PROJECT TITLE: DAN LAWSON DEVELOPMENT ZONE ATLAS/DRNG. FILE #: G-15/D43

August 10, 1993

RE: DRAINAGE PLAN FOR DAN LAWSON DEVELOPMENT (G15-D43) ENGINEER'S
STAMP DATED 8/9/93.

**SITE PLAN**  
**GRADING & DRAINAGE PLAN**  
**DALE LAWSON DEVELOPMENT**  
**COMANCHE ROAD N.E. AT I-25**  
**ALBUQUERQUE, NEW MEXICO**  
**AUGUST, 1993**

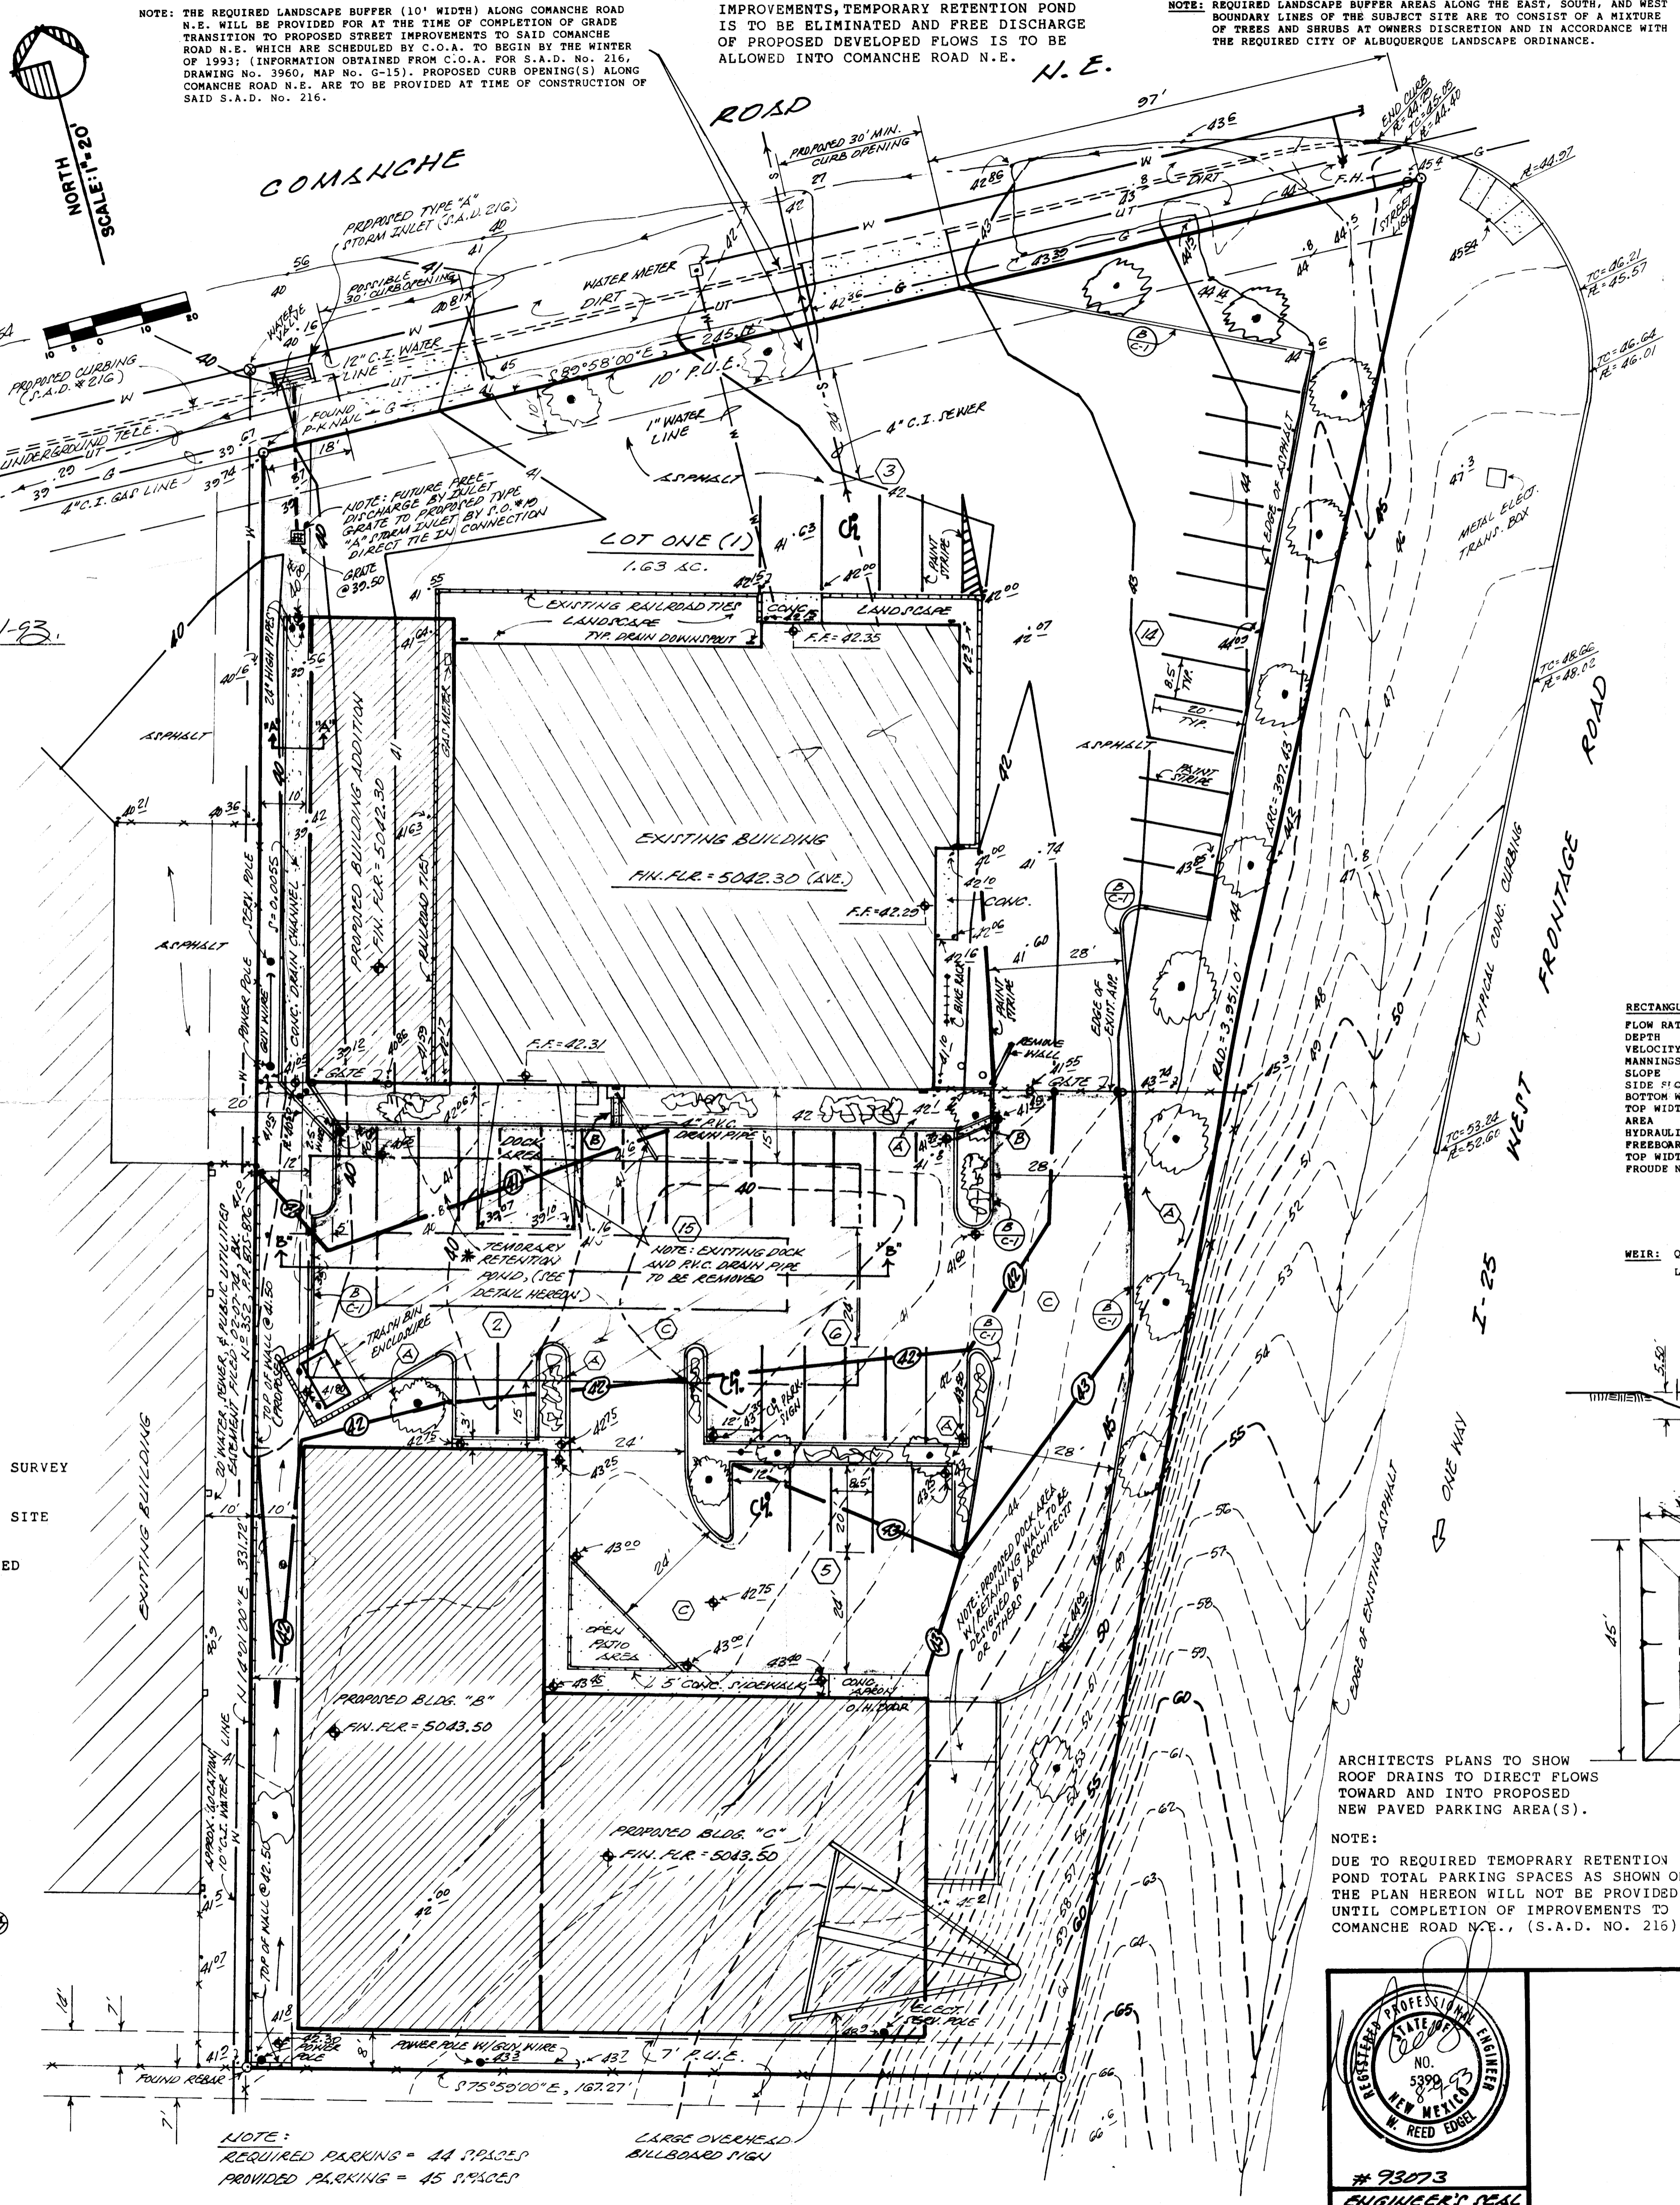
Also, it will be the responsibility of the owner when the S.A.D. is completed to fill in the temporary retention pond and allow for free discharge down towards Comanche. Please keep in mind that the ponding area is only temporary. The proposed inlet to connect to the existing storm inlet will need to be engineered.
